Subject – Objection to SSD-93020230

40-48 Redan Street Mosman NSW 2088.

To the Commissioner of the Housing Development Authority **[HDA]**

Sheet
2112

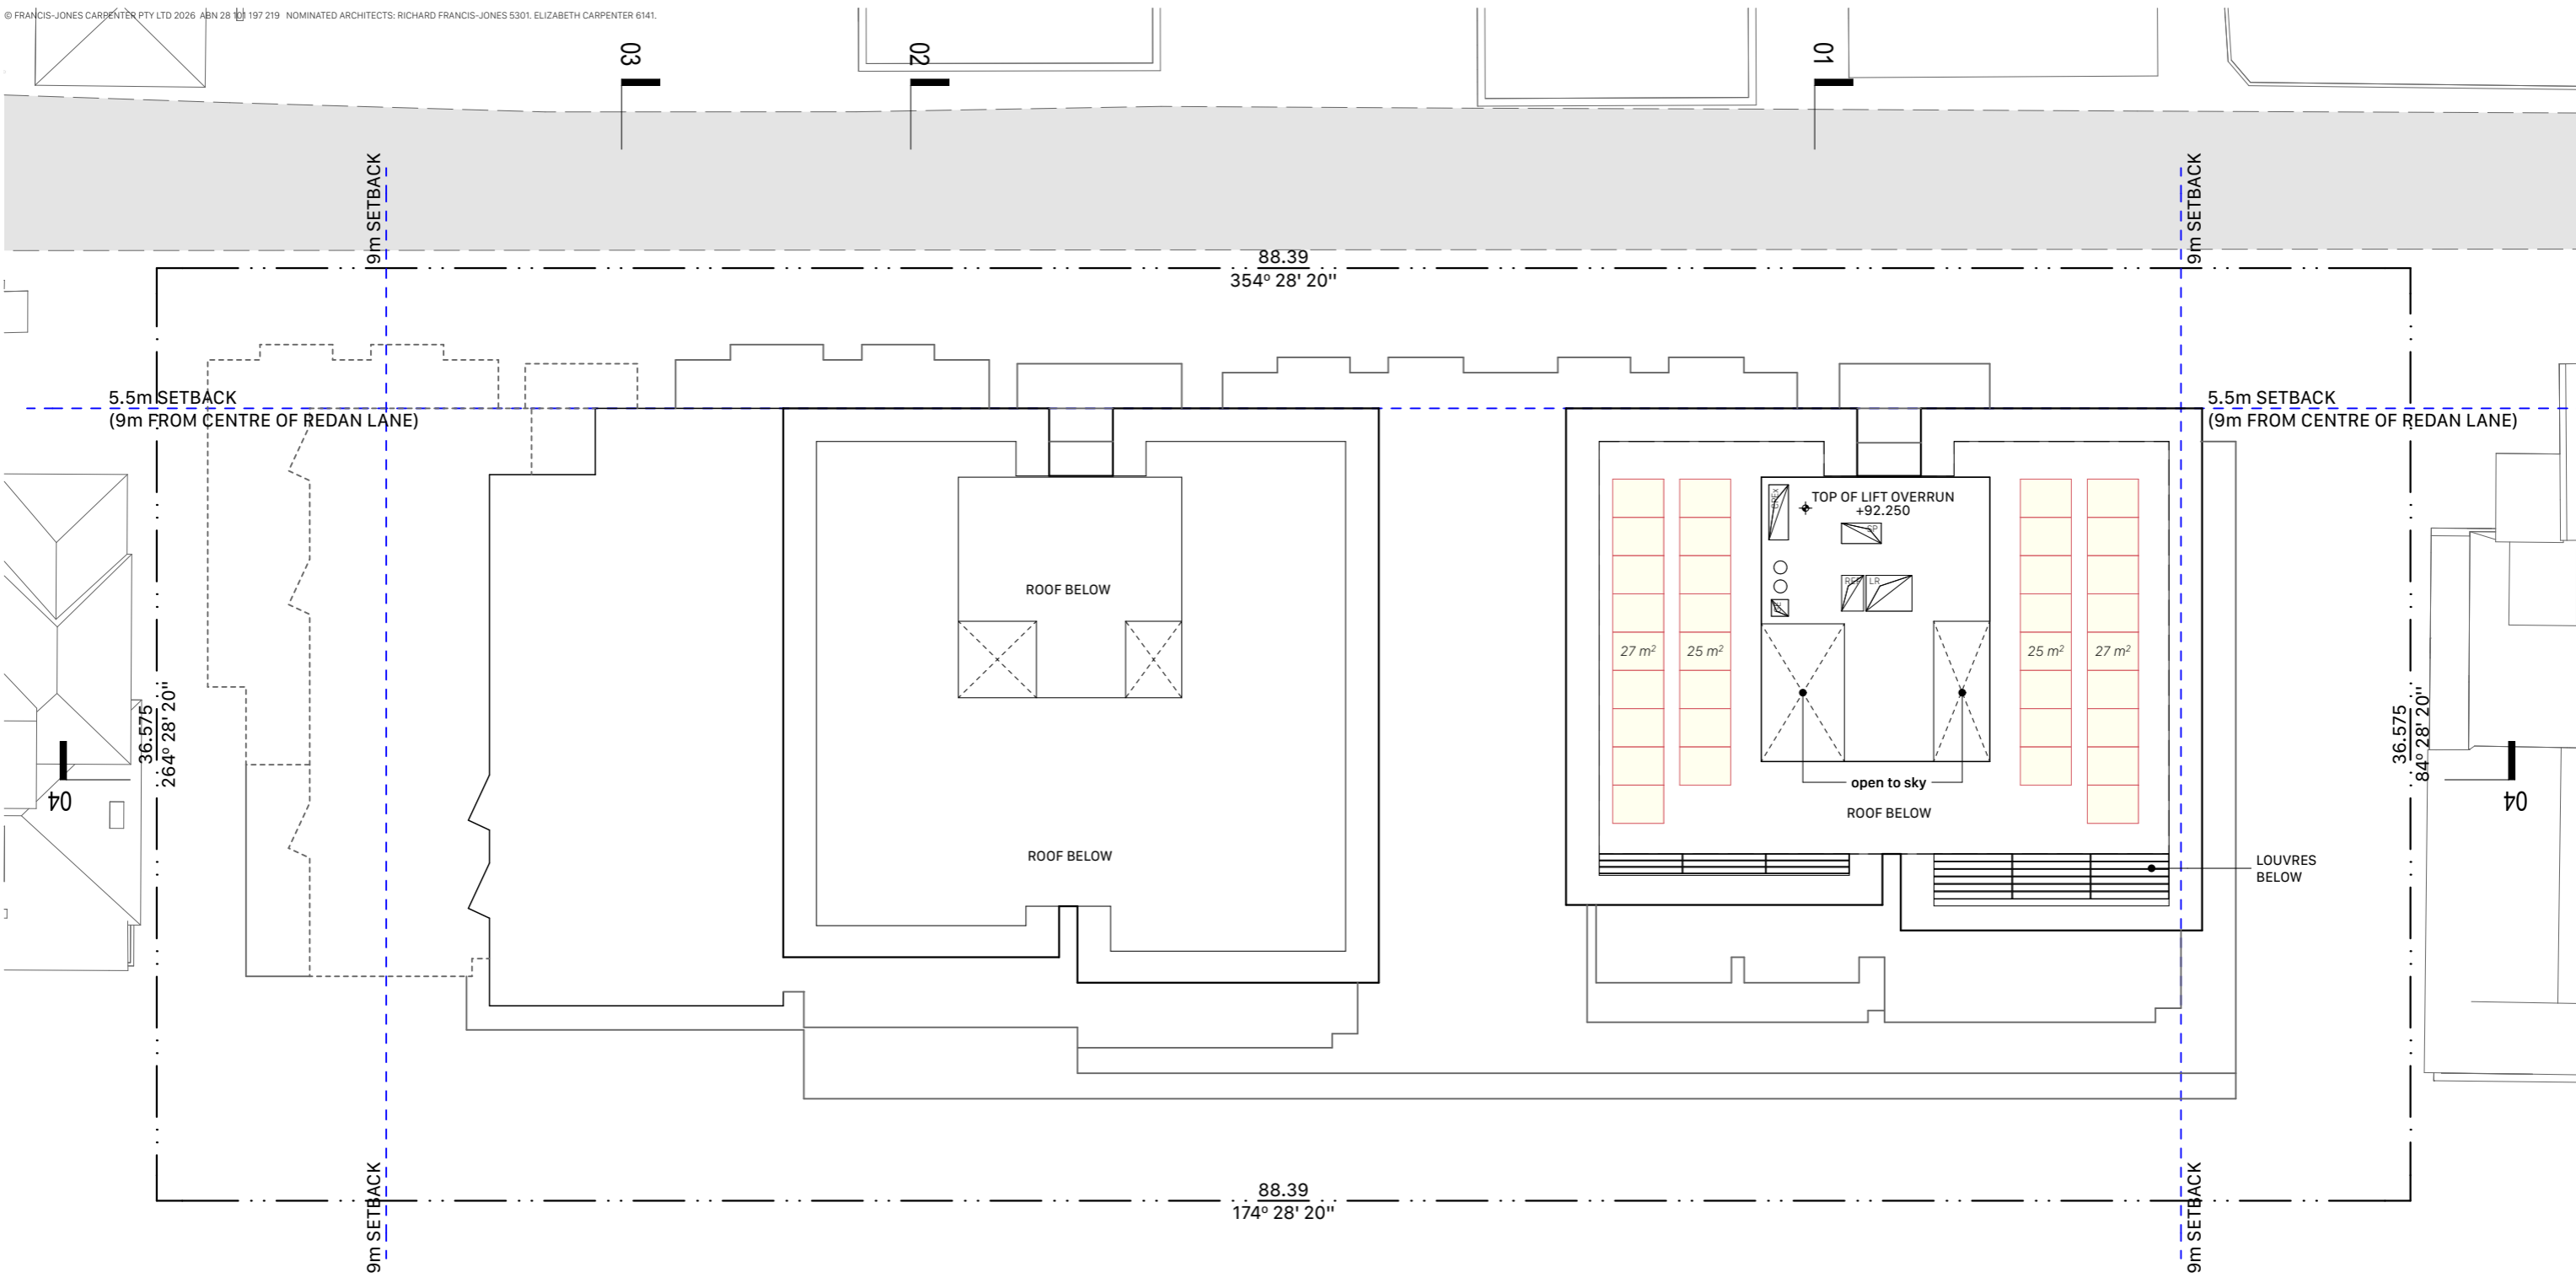
- Yet, when you look at the floor plan for the roof there is an additional roof plate without an accurate RL, that shows solar panels on a roof structure above the previous roof plan. See sheets 2112 and 2113

- Sheet 2112

- Sheet 2113 indicates an additional roof with solar panels. This if looking at the elevations I would conclude is at RL 95.350.

- This may be a subversive way to create an 11th storey, and may be utilised for something like a Community Open Space for the northern tower.
 - If this were to be so, it would be a further breach of the height and FSR calculations
 - I believe the HDA should seek written undertakings from the developer that they are not to utilise add roof space for additional structure above what is shown on their application.
- What is most worrisome is, that should this be approved, it will potentially set a precedent for other developments to similarly to breach the SEPP allowances

40-48 Redan Street, Mosman 40-48 Redan Street Mosman NSW 2088	Elevation West - Redan Lane Elevations	Rev Date Description By Chk	Scale	Code	Sheet	Rev	0 2.5 5 10m
		B 27/2/2026 SSD Submission Lodgment IS	1:250 @ A3	TPRS	3003	B

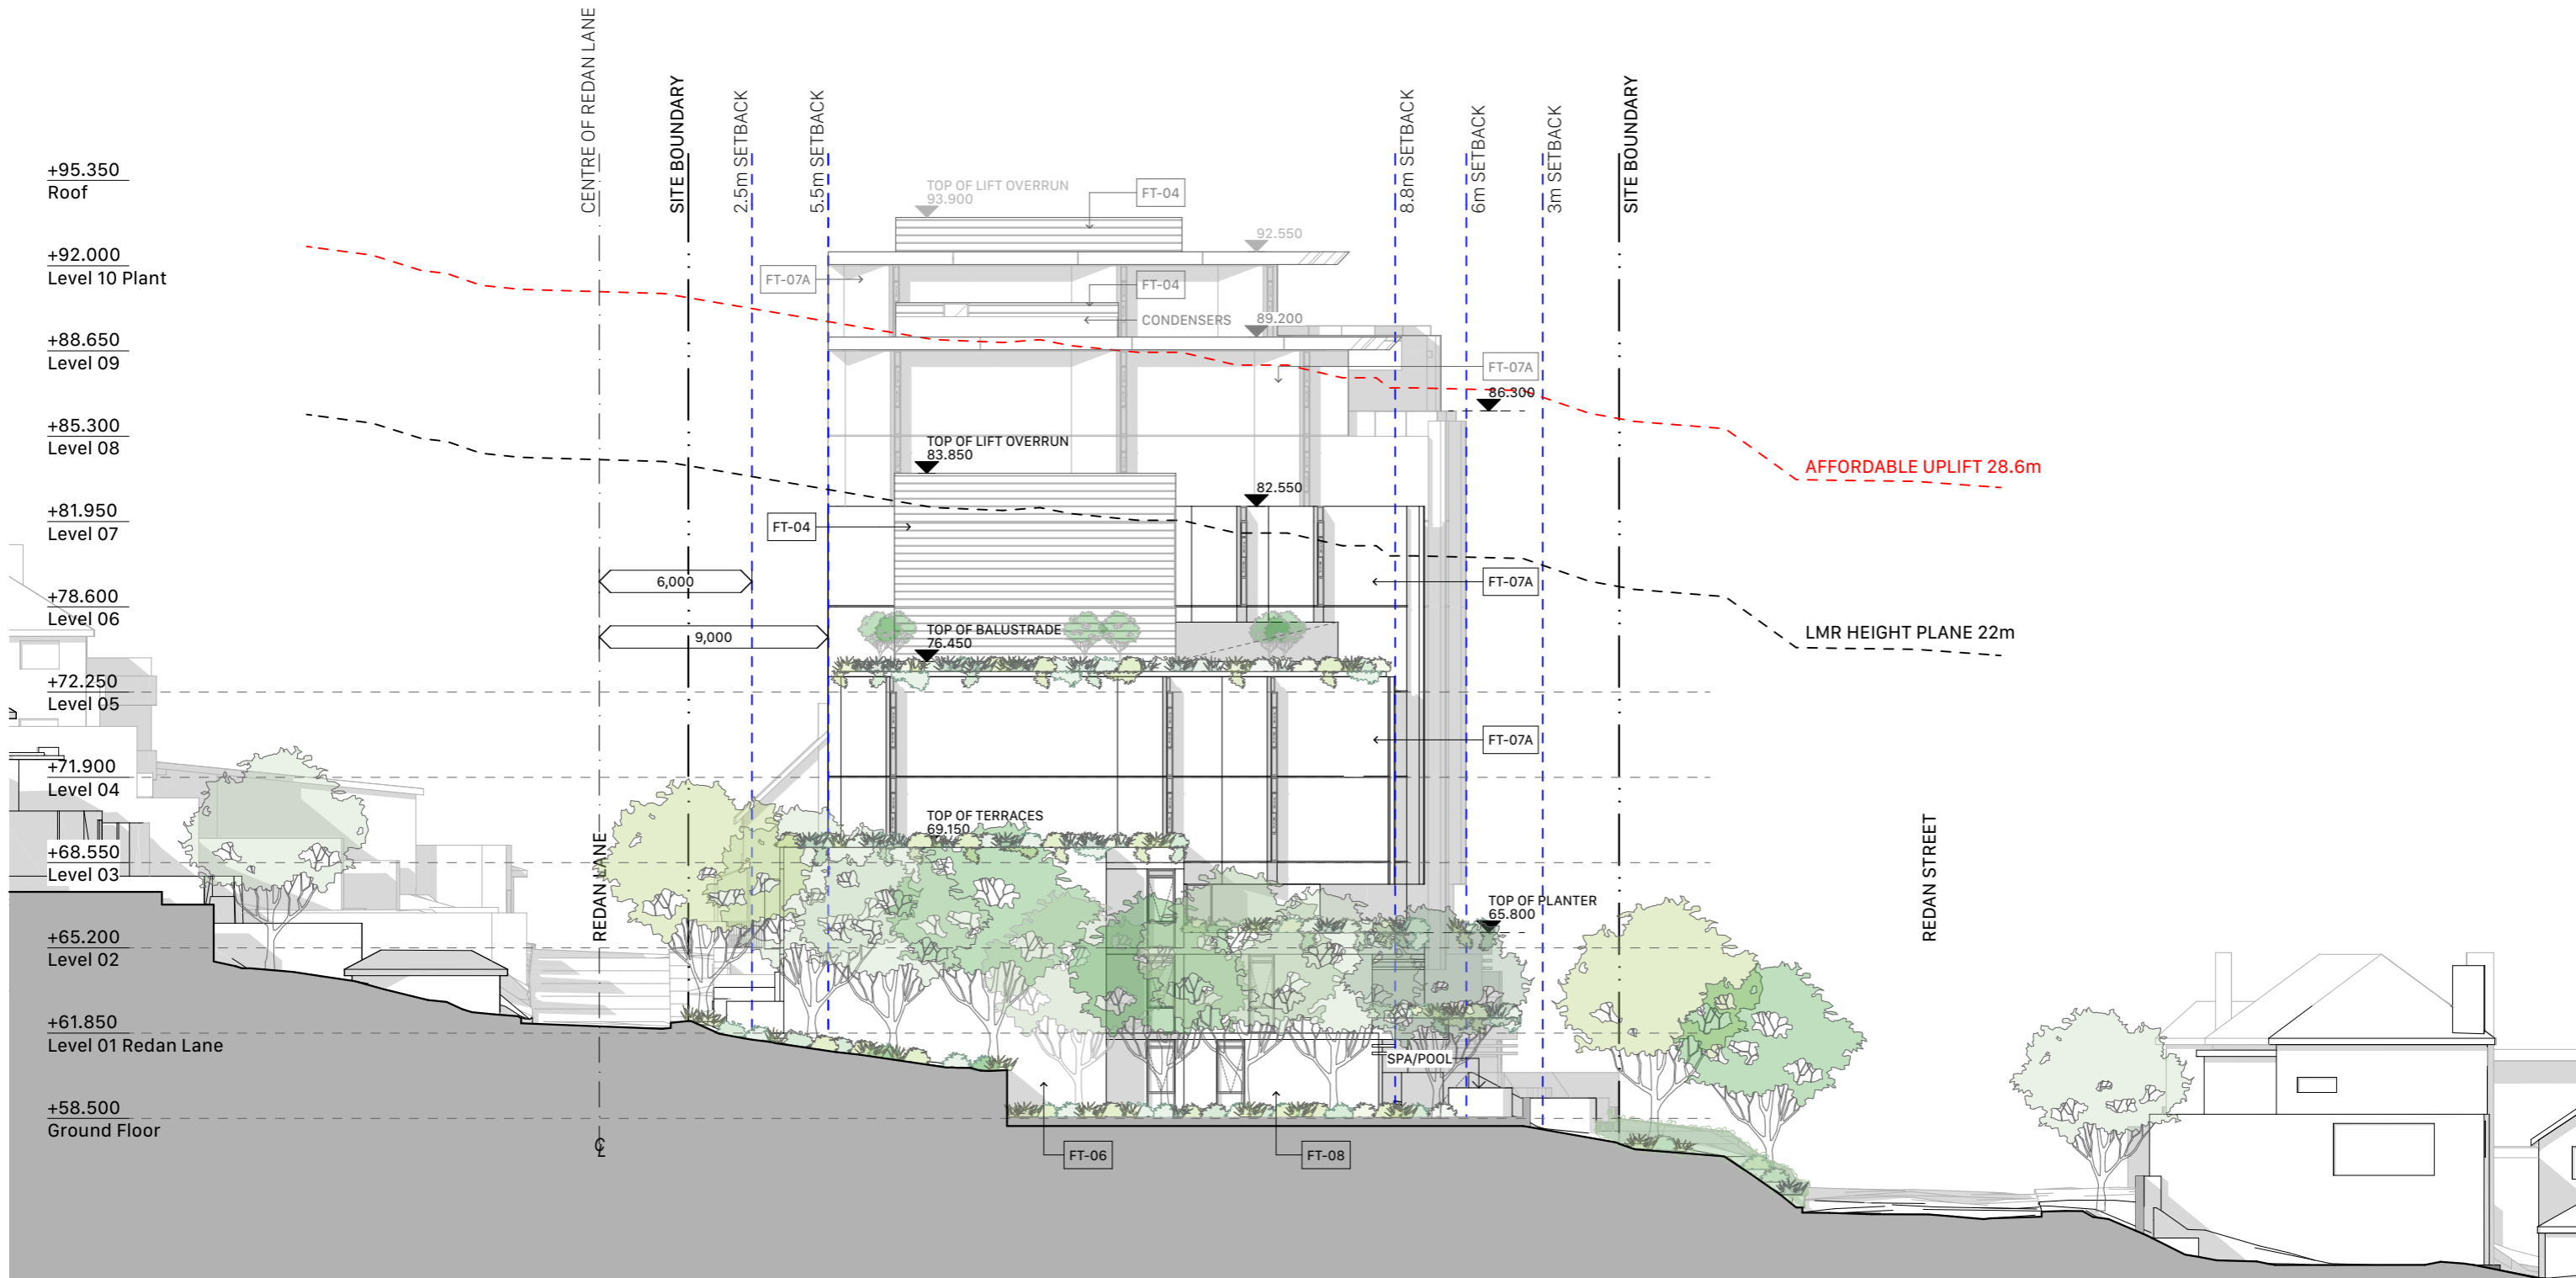
- There is also a misrepresentation in the Architectural Plan Set. Please review the elevations shown on Drawing 3003.
 - It shows that the roof over the rooftop plant is at RL 93.900

- On the far left presentation of RL's of each floor, it reflects that there is a roof height for the 'Roof' level at 95.350.
 - That roof at 95.350 is not shown on the elevations on sheet 3003
